Located At 51 CONGRESS ST

Job ID: 2011-10-2481-ALTCOMM

has permission to Add a Deck off the 3rd floor over an existing footprint between house & barn, support down through barn provided that the person or persons, firm or corporation accepting this permit shall comply with all of the provisions of the Statutes of Maine and of the Ordinances of the City of Portland regulating the construction, maintenance and use of the buildings and structures, and of the application on file in the department.

RE: 51 Congress Street - #014-K-009 - R-6 Zone - #2011-10-2481

PAGE 1 OF 3
By Anthony Taylor
in consultation with
Joseph H. Leasure, P.E.
REVISED OCT 2, 2011

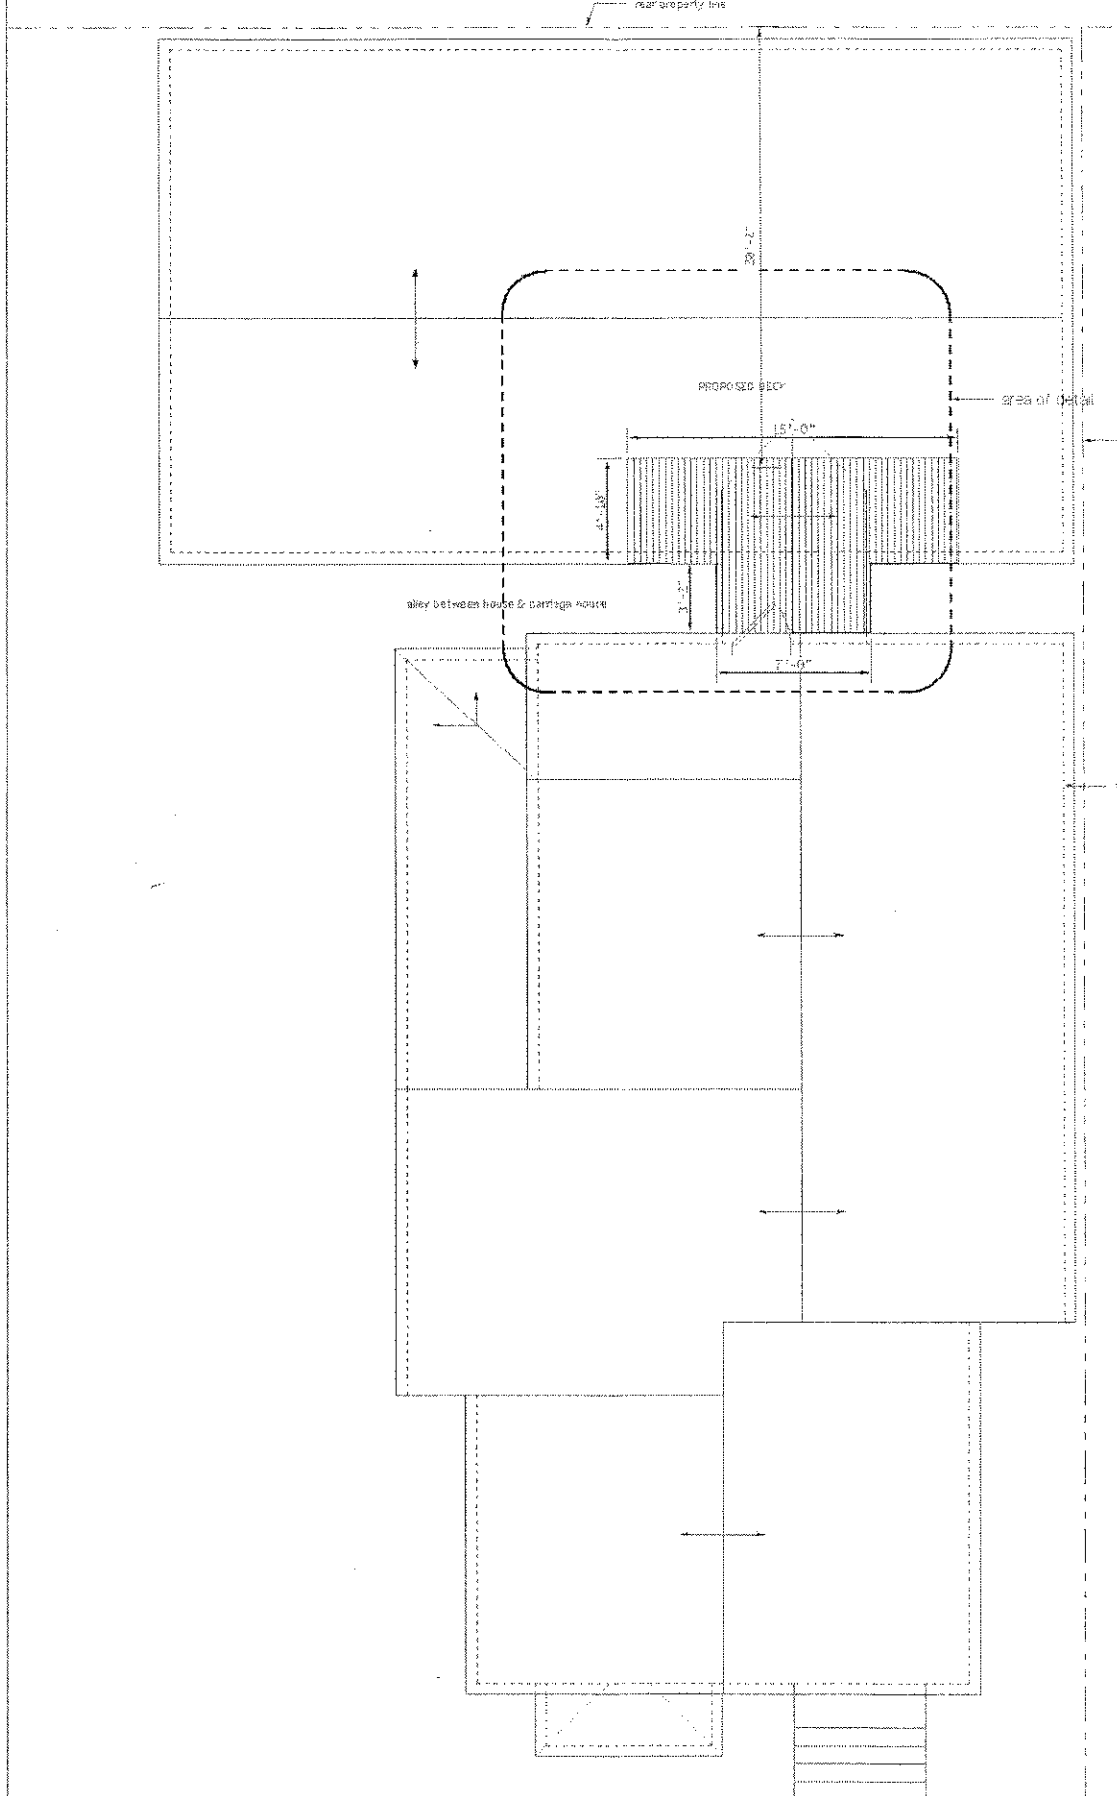
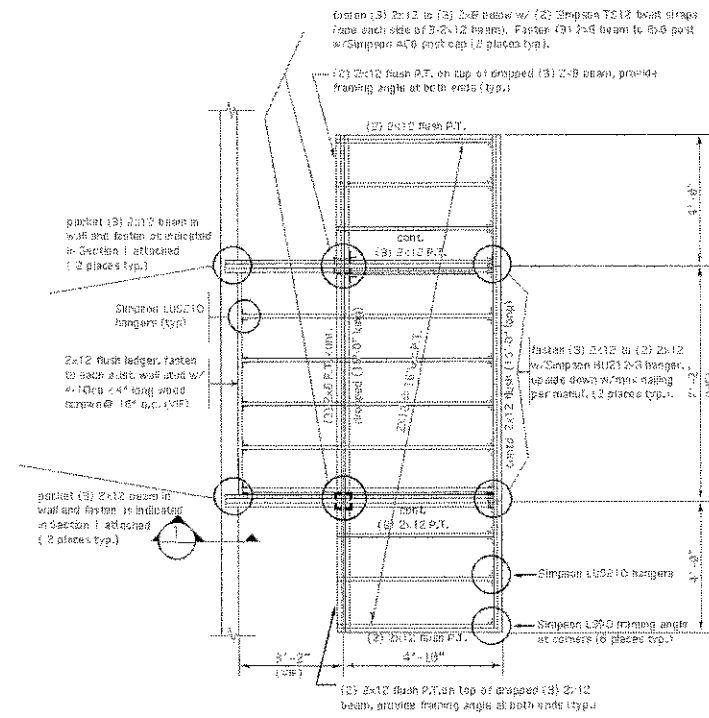
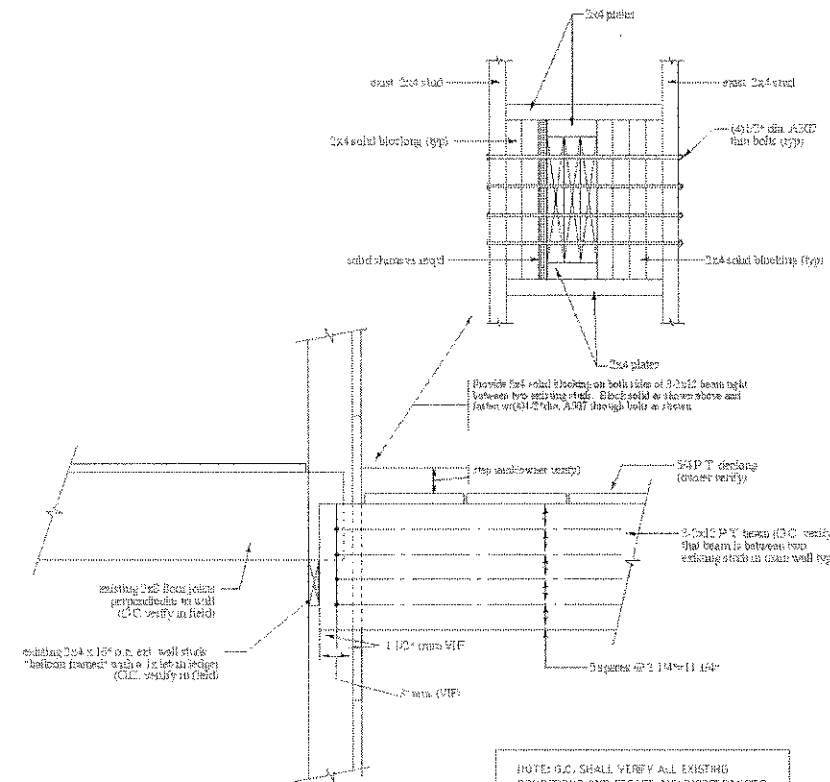
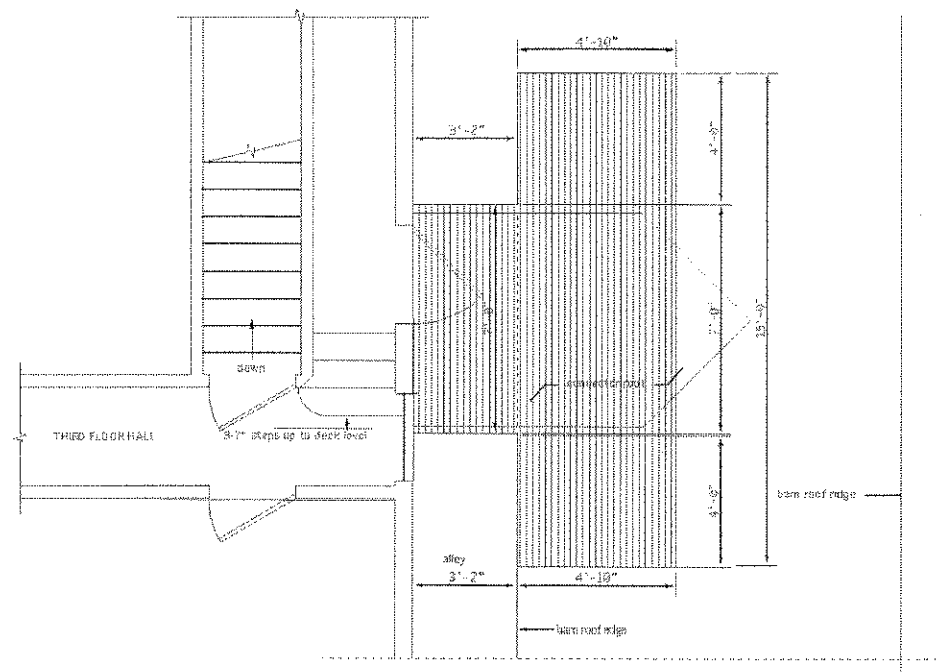
3. Per discussion with David Cray, the new interior steps to access the door will comply with IRC dimensional requirements and a handrail is required per code if the flight has 4 or more risers. Per IBC Sec. 1003.5(1) a single step with a maximum riser of 7" is allowed at the exterior door.

Your permit is denied because it does not meet the requirements of 14-139(e) of the Land Use Zoning Ordinance that limits the amount of lot coverage to no more than 50%. Currently your buildings cover approximately 57.31% of the lot, which is legally nonconforming. Your proposal would increase your legal nonconformity. Please remember that in September 2009 you also applied for such a permit. That permit was denied. On September 14, 2009, our office sent you a letter denying your permit and giving you the legal 30 days in which to appeal. Subsequently on October 2, 2009, our office met with your same contractor David Cray and explained the issues. We never received an appeal application within the legal time frame and we never received revised plans showing revisions that would meet the Land Use Zoning Ordinance. Because of your inaction during the legal time frame, your current building permit application is denied. Our original decision is binding and not subject to appeal.

2. This approval is granted based on plans reviewed and modified by the consulting engineer, per the letter dated 4/6/12. Any discrepancies or changes shall be approved by him and submitted to this office.
